Formal Objection to planning application 20/00934/FUL for 7 houses on land to the rear of The George Inn, Sandford Road, Littlemore (amended plans)

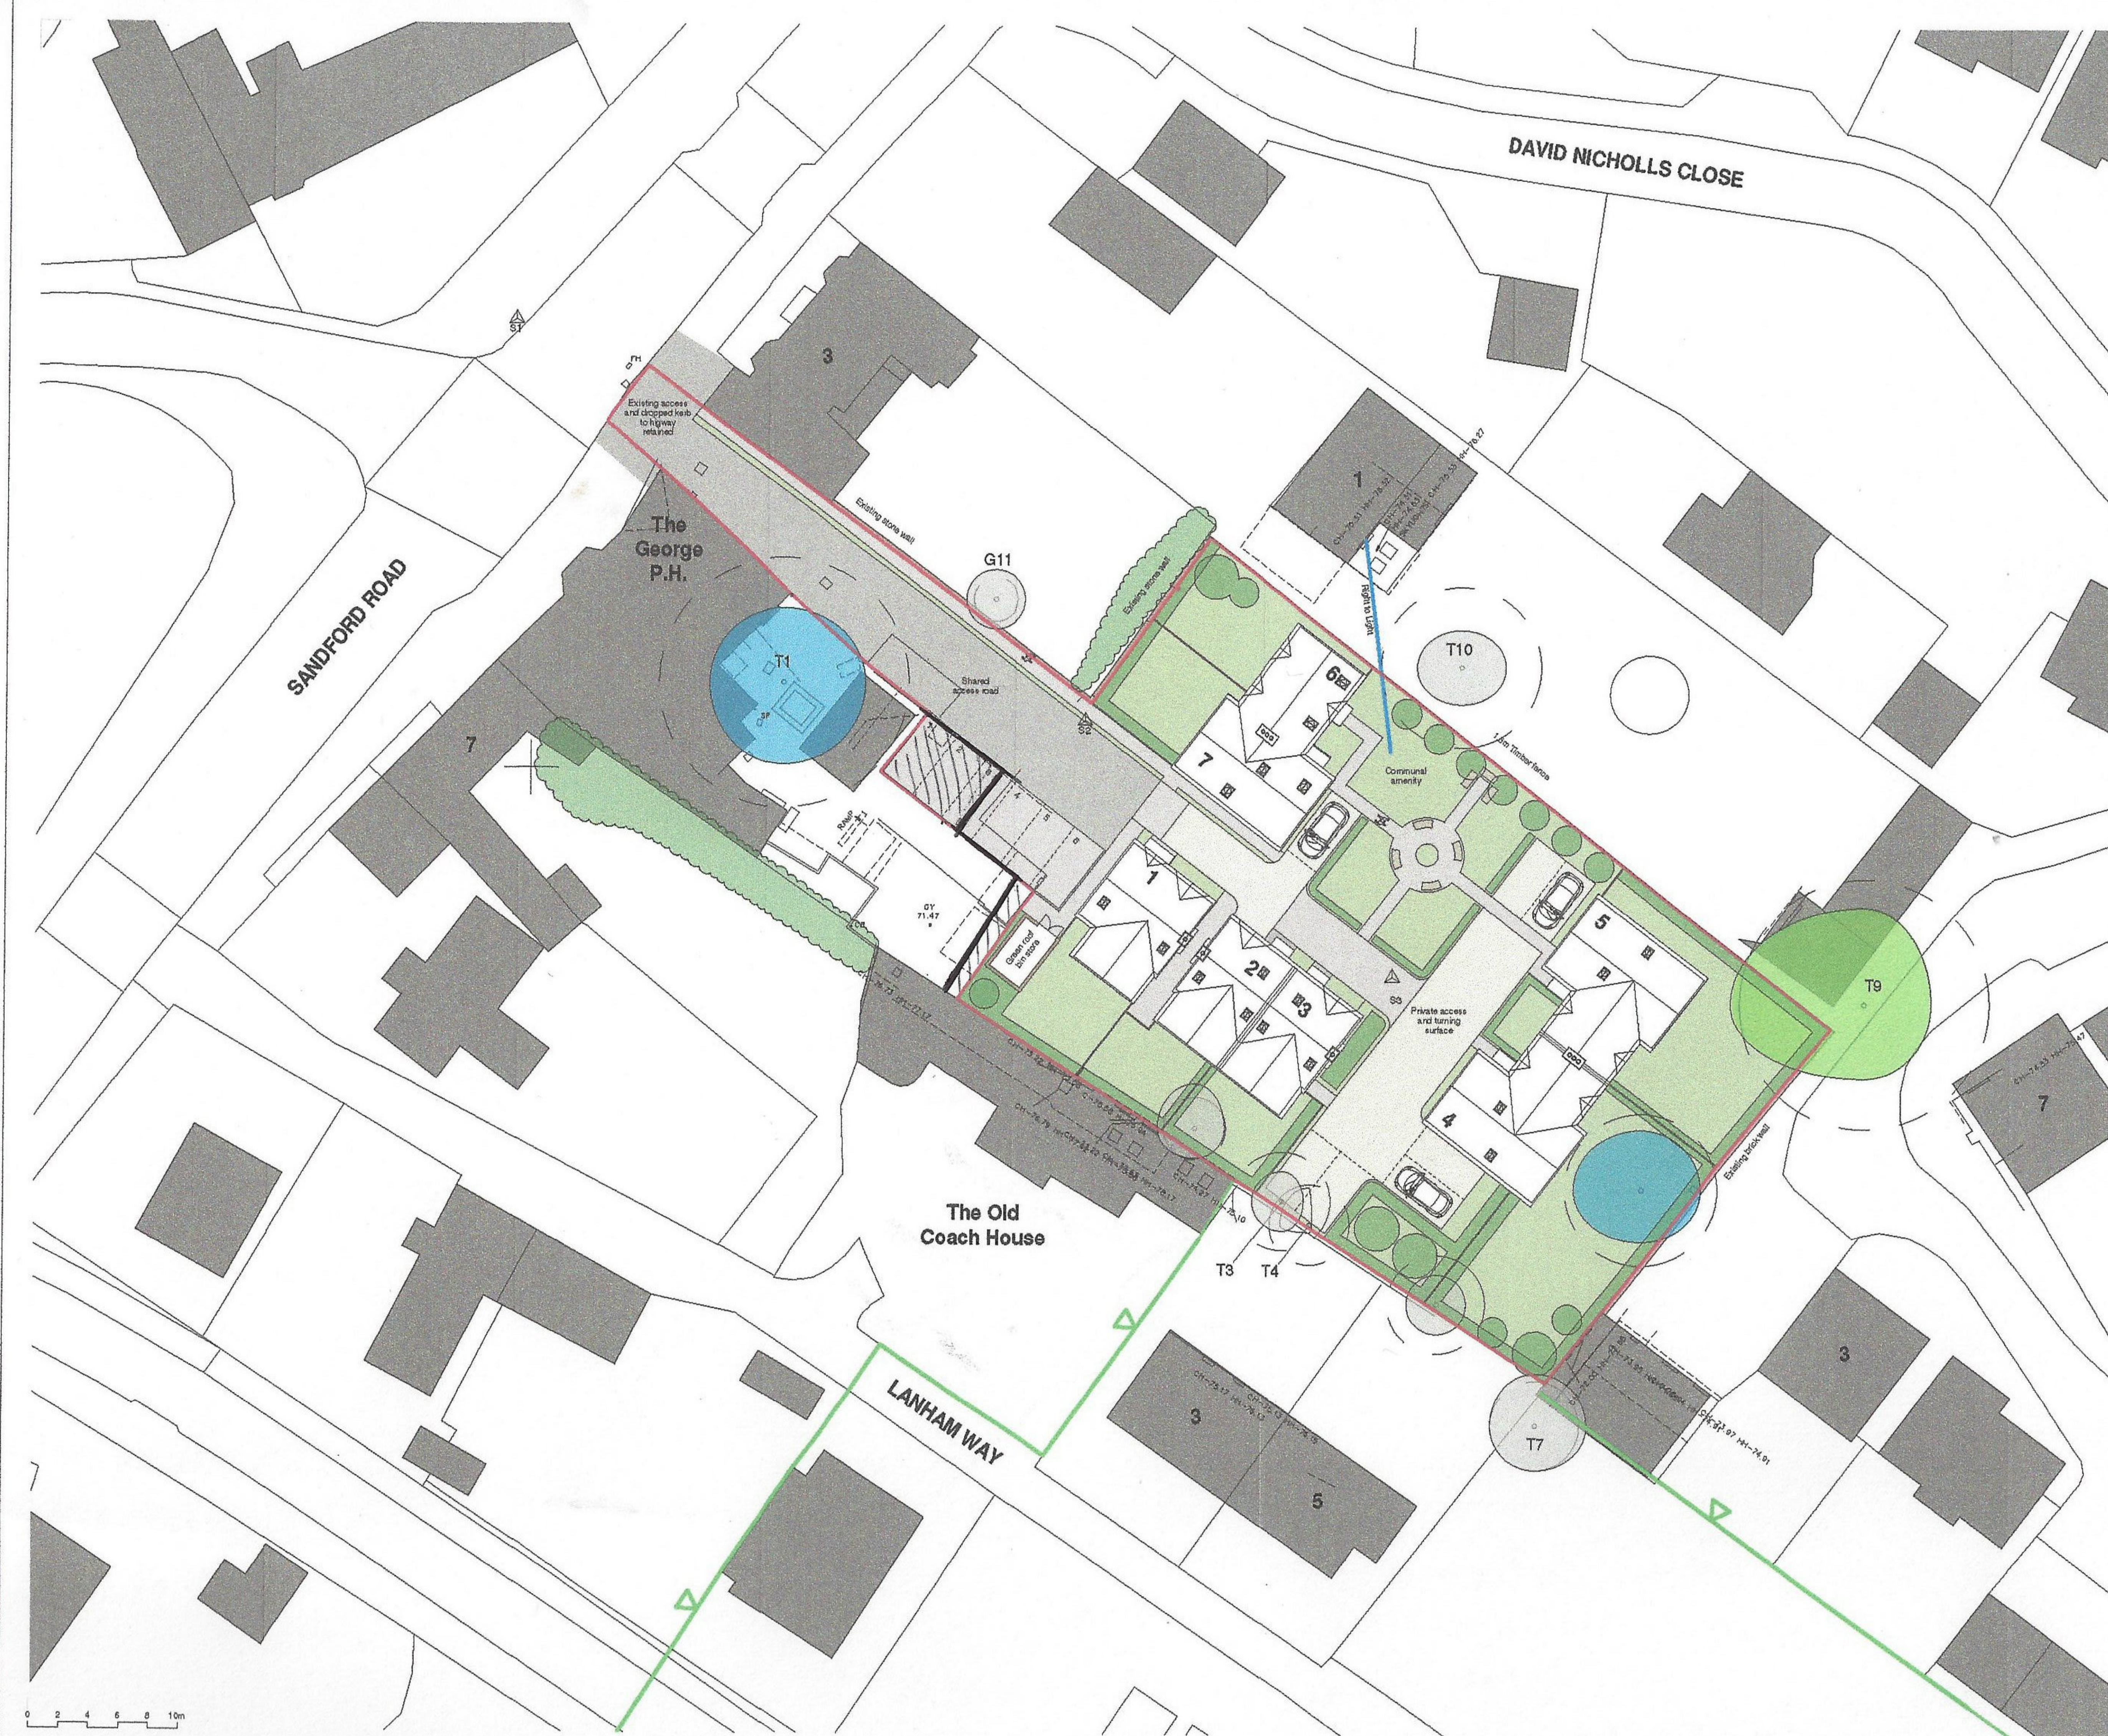
Furthermore, the application documents (Forms, D&A and Transport Statement) indicate that 6 spaces would be created for use by the retained public house, including the demolition of a wooden structure behind the pub to make way for the parking spaces. However, there is a significant issue with the way the plans have been drawn. The application boundary shows 3 spaces to fall outside of the application boundary and therefore cannot be delivered by this application. There are no parking spaces in this location apart from some parallel spaces running in line with the access road. Which means the proposed parking spaces would have to be physically constructed and therefore should fall inside the application boundary. It is understood that the applicant does not own or control the land outside the redline which calls into question the ability of the applicant to construct these parking spaces, regardless of whether they are within the red line or not and furthermore, whether they have permission to demolish the wooden structure as this is part of the public house.

Ultimately this means the application can only provide 3 parking spaces for the public house, as the remaining 3 spaces are not included within the application boundary. This is not acceptable and 3 spaces does not meet that Councils required parking standard. It would severely affect the ability of the public house to trade effectively.

The spaces are proposed to be accessed directly off the narrow, shared access road. The narrowness of this road, results in very awkward and difficult spaces to access. It will lead to conflict between pub customer traffic and residents. The Council should ask the applicant to provide evidence to show that vehicles can safely and easily access these parking spaces. It seems that vehicles would have to mount the proposed footpath to be able to turn in and out of these spaces.
